**Planning Department
Transportation Development Services**

May 14, 2015

Re: Car Crafters
5600 Holly Ave. NE
Traffic Circulation Layout
Engineer's/Architect's Stamp dated 3-24-15 (C18-D044)

TCL SITE PLAN

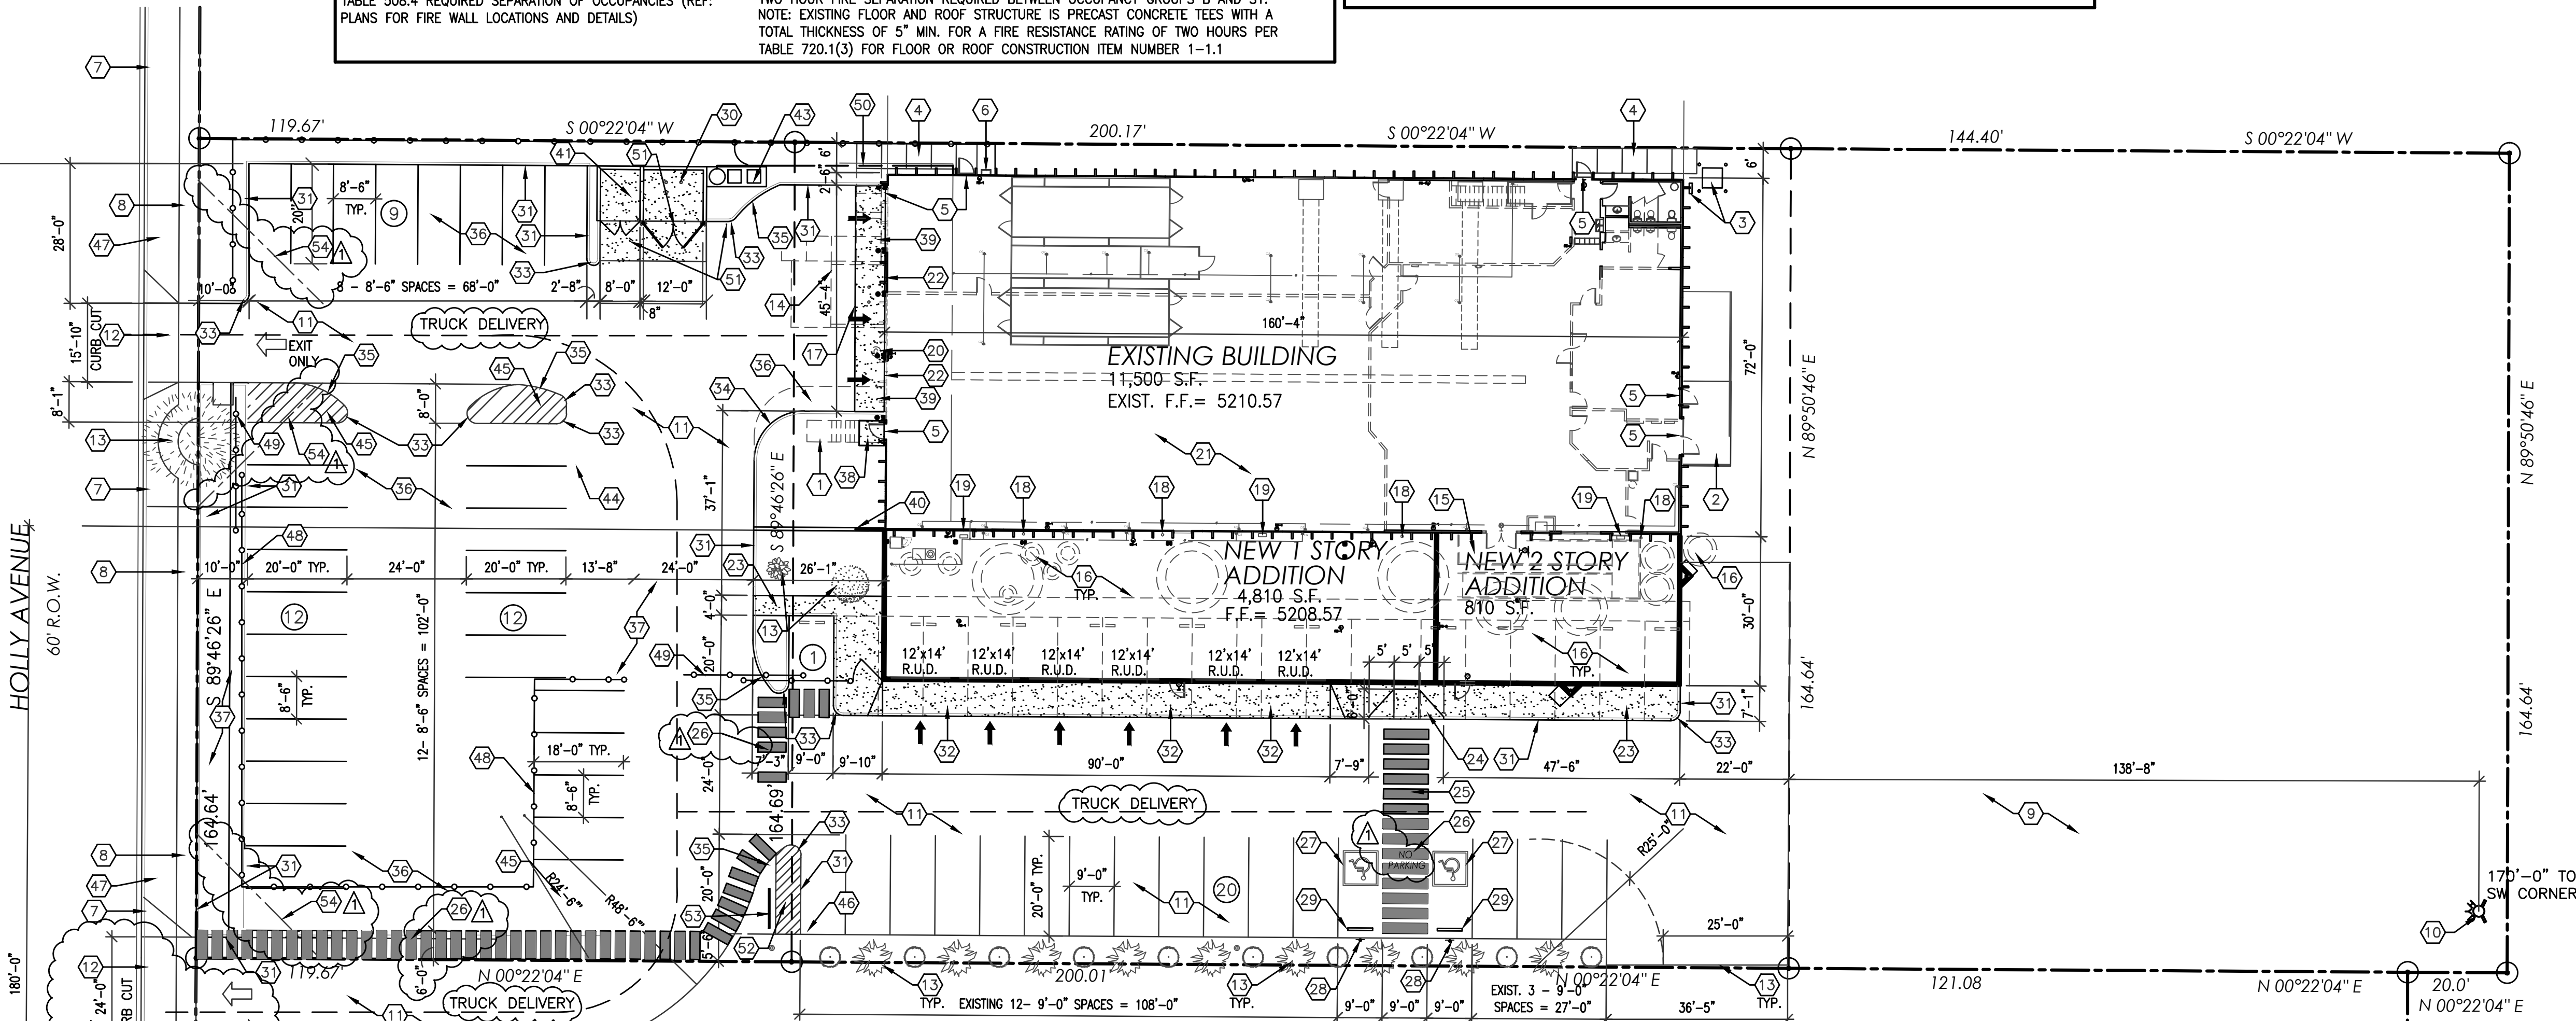
1. Please identify and dimension both exiting drive pads and ensure that they comply with the Clear Sight Triangle requirements. Ensure that the existing tree does not interfere with Clear Sight requirements.
2. Please provide a sight distance exhibit (see the *Development Process Manual*, Chapter 23, Section 3, Part D.5 Intersection Sight Distance).

3. Please add the following note to the clear sight triangle: "Landscaping and signage will not interfere with clear sight requirements. Therefore, signs, walls, trees, and shrubbery between 3 and 8 feet tall (as measured from the gutter pan) will not be acceptable in this area."
4. Please list the width and length for all parking spaces. The lengths of the parking spaces on the west side and north side are not dimensioned.

5. The ADA accessible sign must have the required language per 66-7-352.4C NMSA 1978 **"Violators Are Subject to a Fine and/or Towing."**
6. The ADA access aisle shall have the words **"NO PARKING"** in capital letters, each of which shall be at least one foot high and at least two inches wide, placed at the rear of the parking space so as to be close to where an adjacent vehicle's rear tire would be placed. (66-1-4.1.B NMSA 1978)

7. Show all drive aisle widths and radii.
8. Per the DPM, a 6 ft. wide ADA accessible pedestrian pathway is required from the public sidewalk to the building entrances. Please clearly show this pathway and provide details. The Site Drawing does not identify a pedestrian pathway from the public sidewalk.

9. Design delivery vehicle route needs to be shown or provided in an exhibit.
10. Please specify the City Standard Drawing Number when applicable.
11. Work within the public right of way requires a work order with DRC approved plans.
